# CITY OF ALBUQUERQUE

April 13, 2022

**Re: Sequoia Apartments**  
**5130 Sequoia Rd. NW**  
**Traffic Circulation Layout**  
**Architect's Stamp 02-25-2022 (G11D058)**

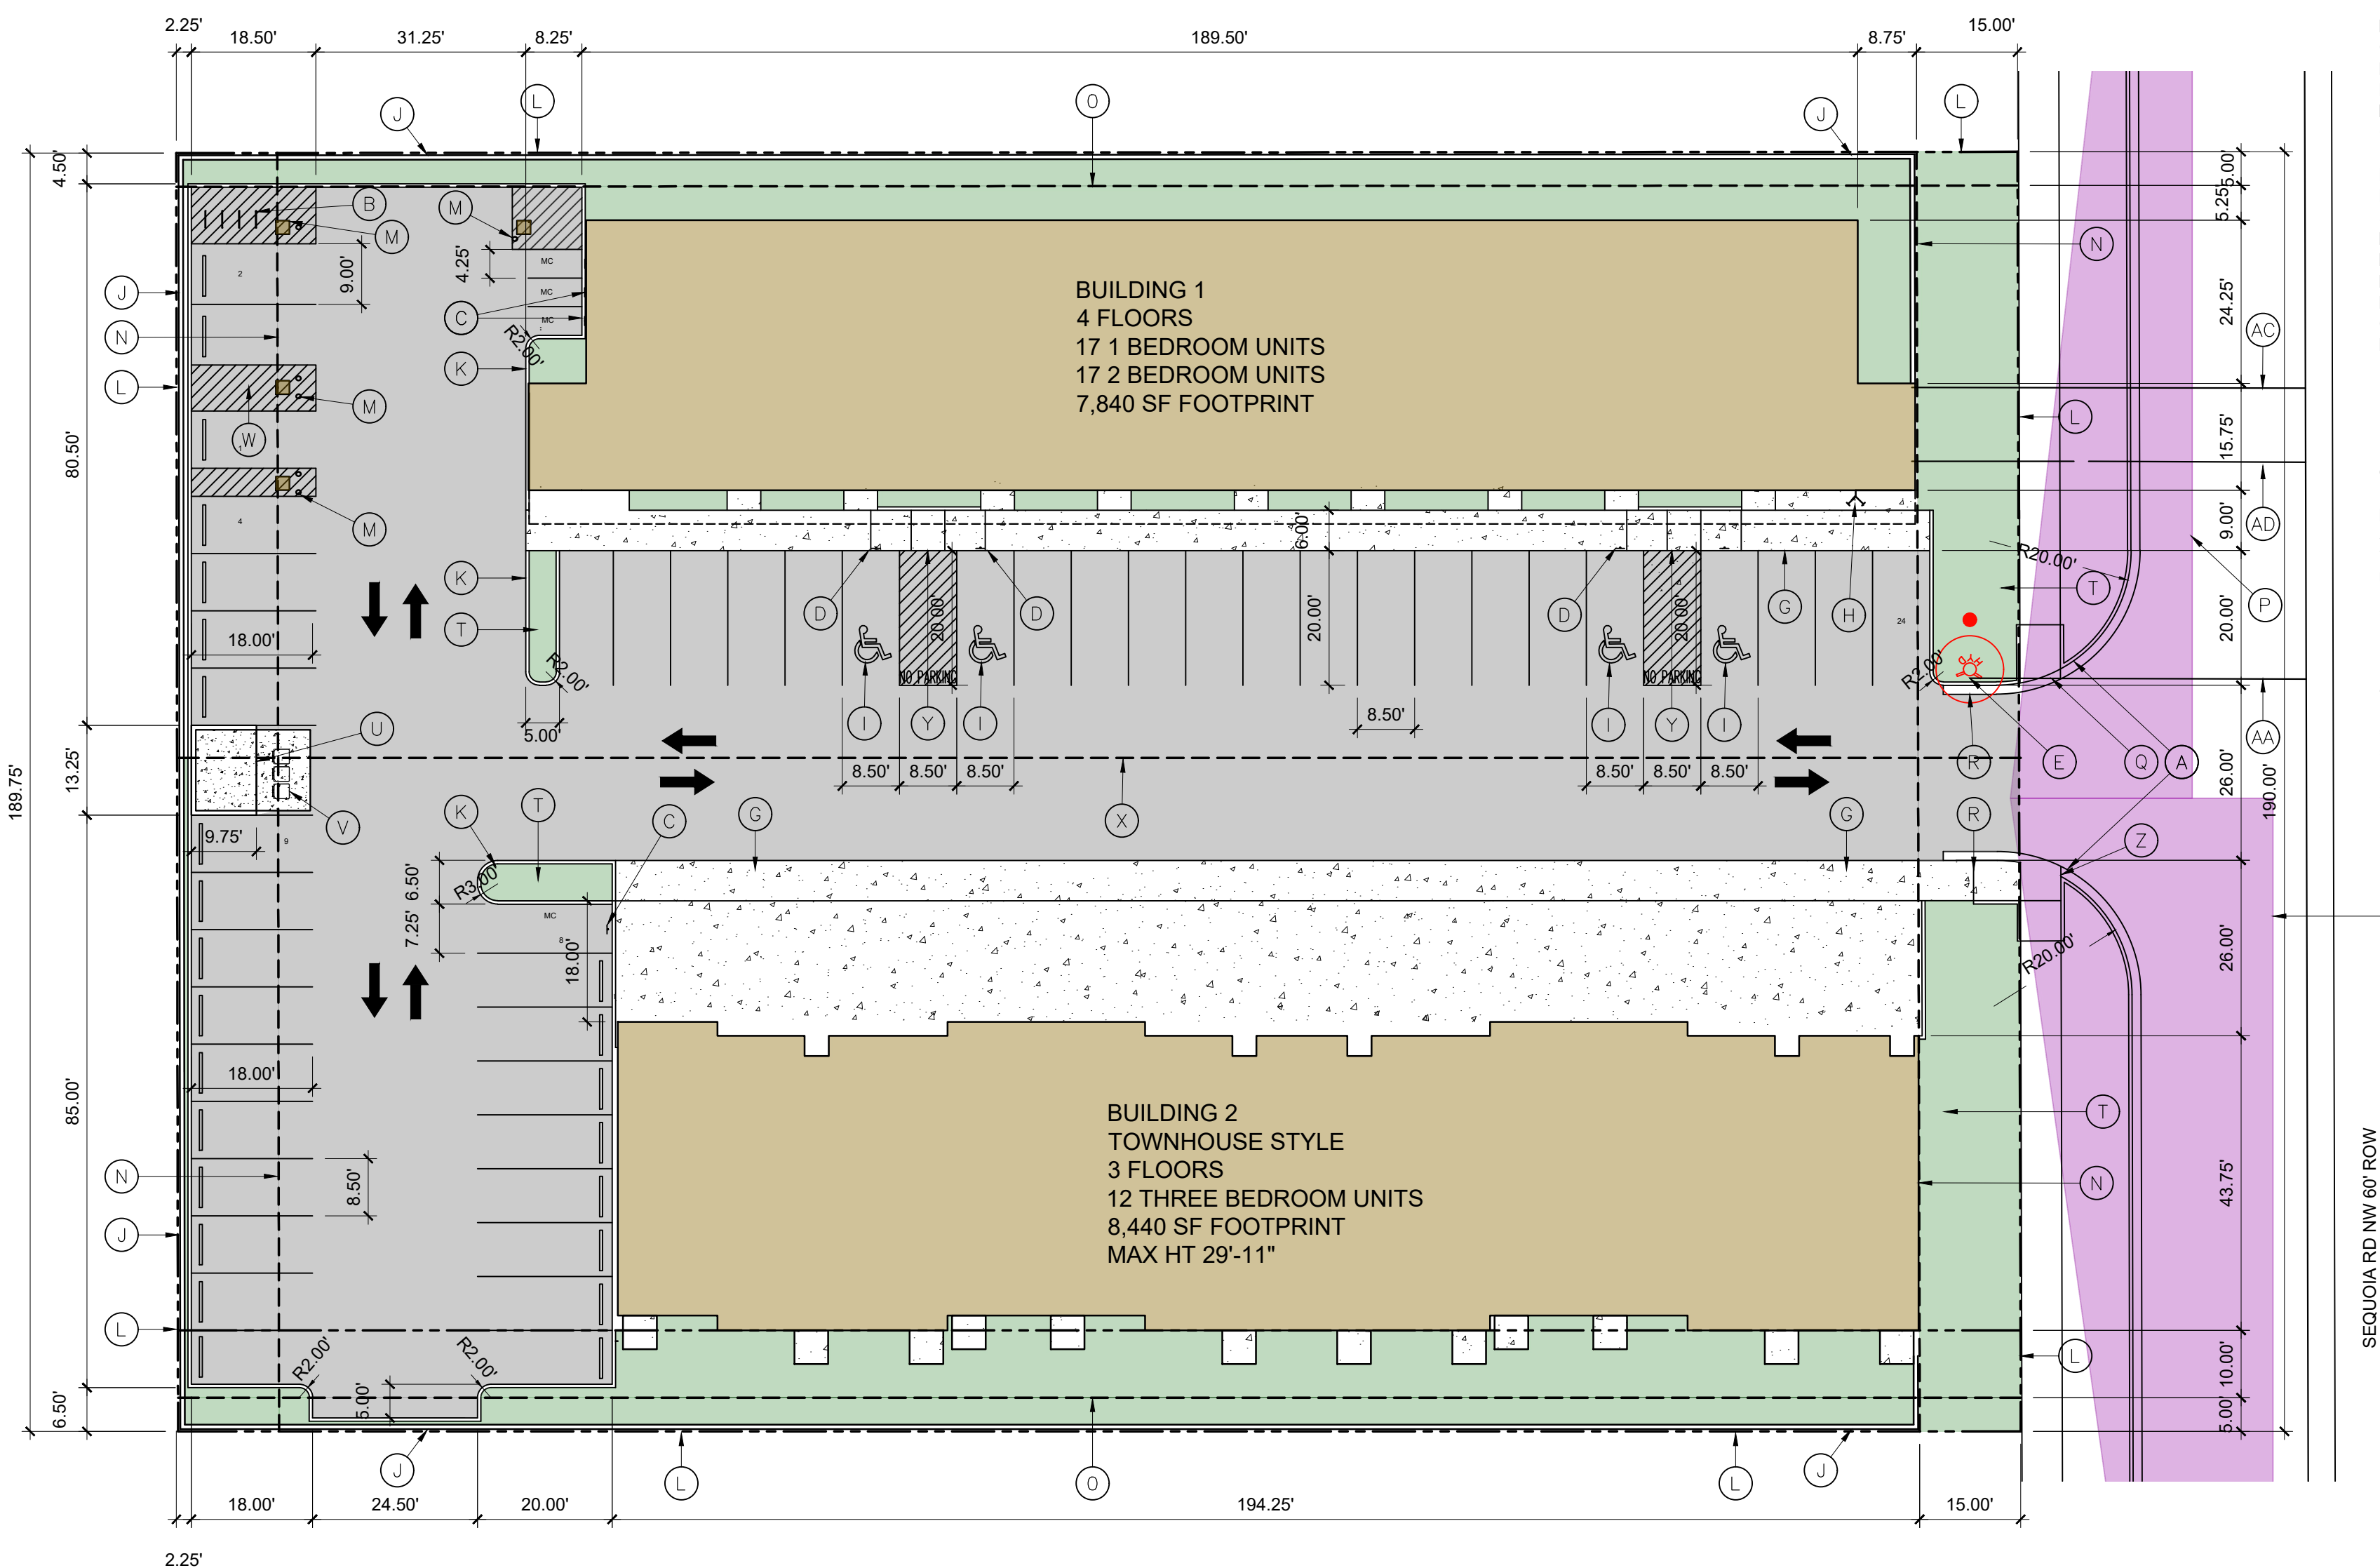
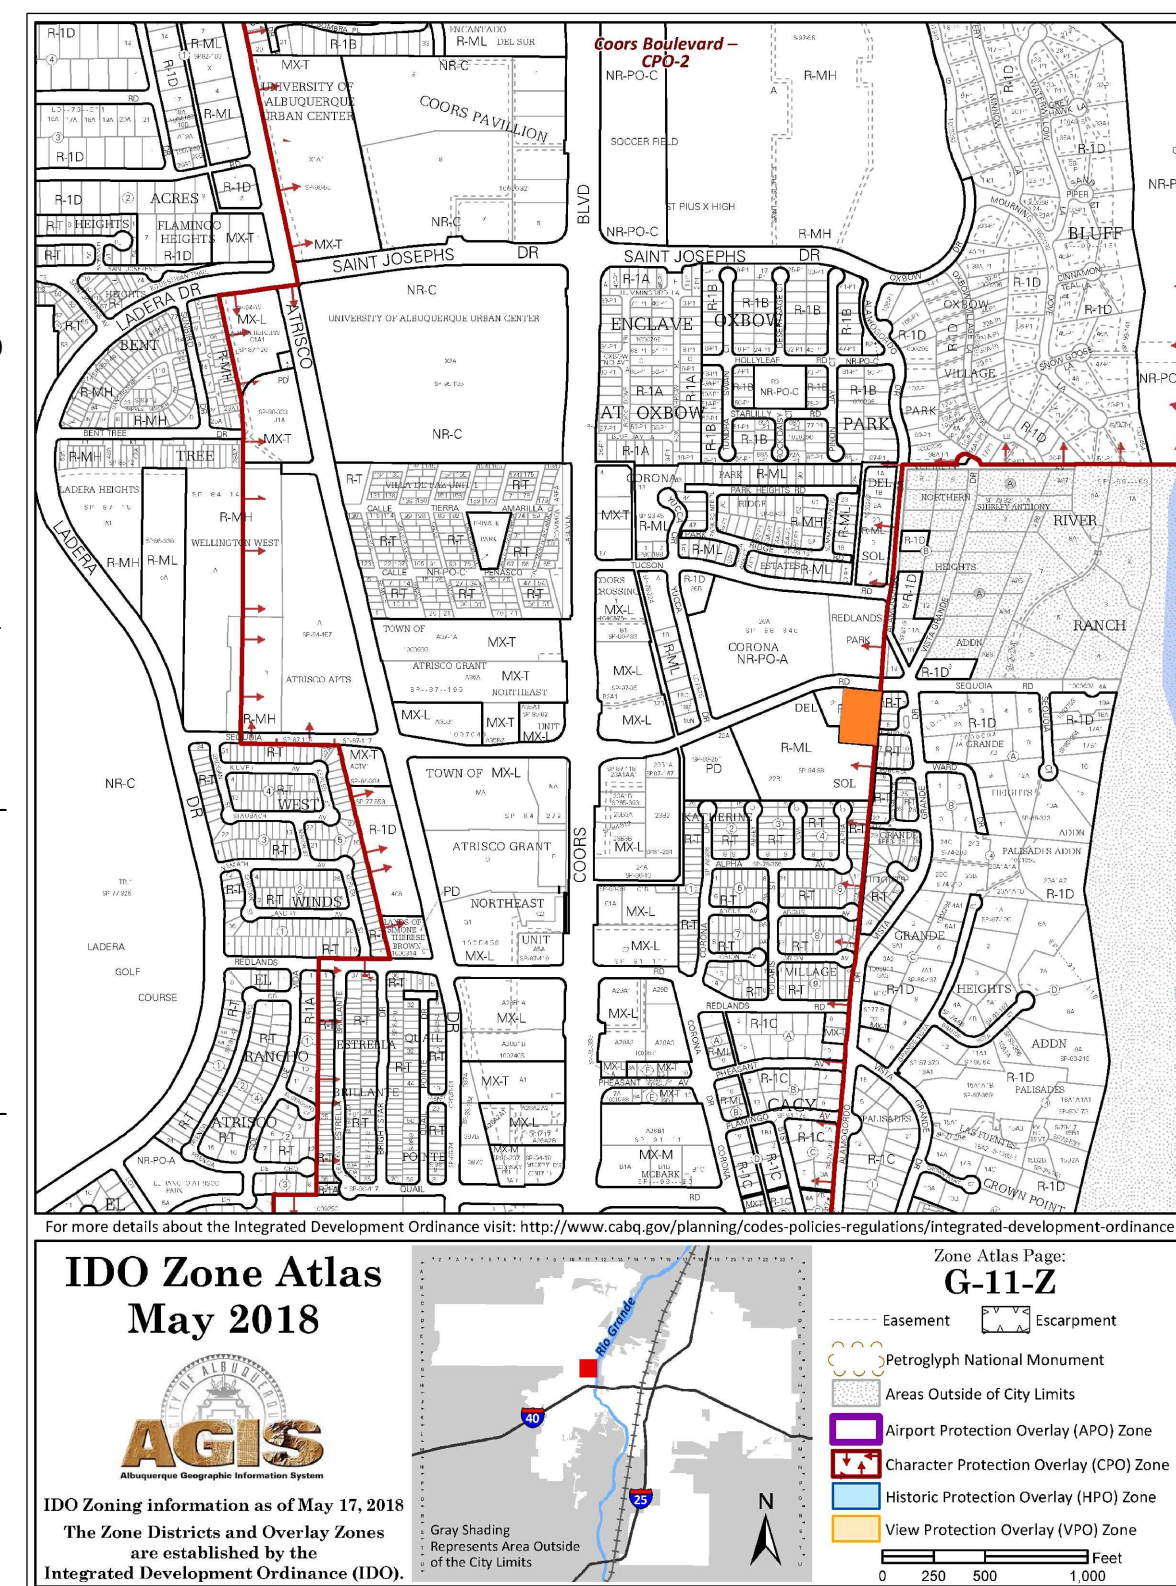
- 20'R-label **TYP.**(typical).
- Your proposed 6ft ADA pathway and ramp are in conflict. A tripping hazard is being created by parallel layout of both infrastructure next to each other and side slopes are being compromised. Please offset 6ft pathway to avoid this safety concern. This is not ADA compliant.

- It appears that Recycling Containers are being located on drive aisle at intersection corner. Please relocate this containers as they will be a circulation concern with vehicular traffic (**keyed note V**).

**3. Keyed Note M:** A detail will be needed and a note specifying to paint the bollards traffic yellow.

- Details will be needed for proposed striping and pavement marking (NO PARKING text).
- Move NO PARKING pavement marking text onto the access aisle.

**5. Radius:** please provide all proposed R's on site plan. Some are missing.

- Provide the setback width radii's.

**7.** Add a note stating "All broken or cracked sidewalk must be replaced with sidewalk and curb & gutter." **A build note must be provided referring to the appropriate City Standard drawing (2430 & 2415A).**
